Details of 34 (substation details) of 2019/1573 - Hybrid planning application for a development up to 103,086sqm of employment uses (use classes B1/B2 and B8) and associated works including access roads, drainage and landscaping, a) Outline seeking approval over means of access and scale across 2 development plots (plots 2&3) of up to 71,515sqm floorspace; and b) full application for the development of plot 1 (31,571 sqm floorspace for use B8), associated earthworks and creation of access points including new roundabout to link with Hoyland south Masterplan Area (Local Plan references HS68, HS65, HS61, HS58, HS6, SL5)

Unit 4 (formerly Plot 8), Gateway 36, Development Phase 2 Site, Land South of Dearne Valley Parkway, Hoyland, Barnsley

Condition 34 states:

Proposed Location Plan

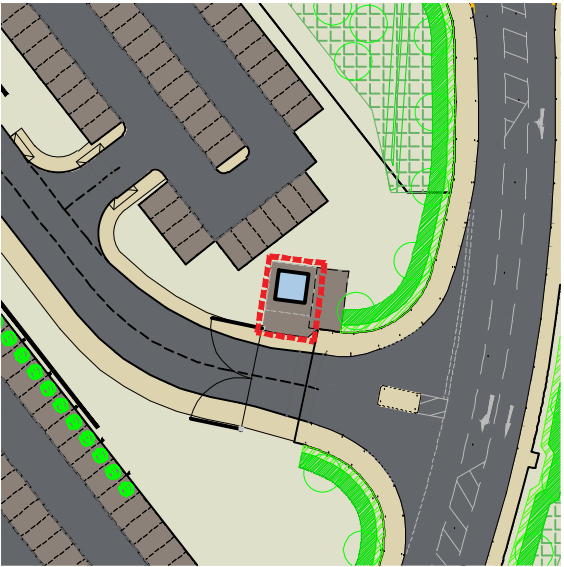
It is noted that the proposed location plan insert on plan ref 12006-4-(P)130 rev.A shows the previous layout (with parking to the East of the substation) and is not reflective of the detail shown on 12006-4-(P)112 rev.F

Notwithstanding this, as the details of the substation are acceptable, condition 34 can be discharged.
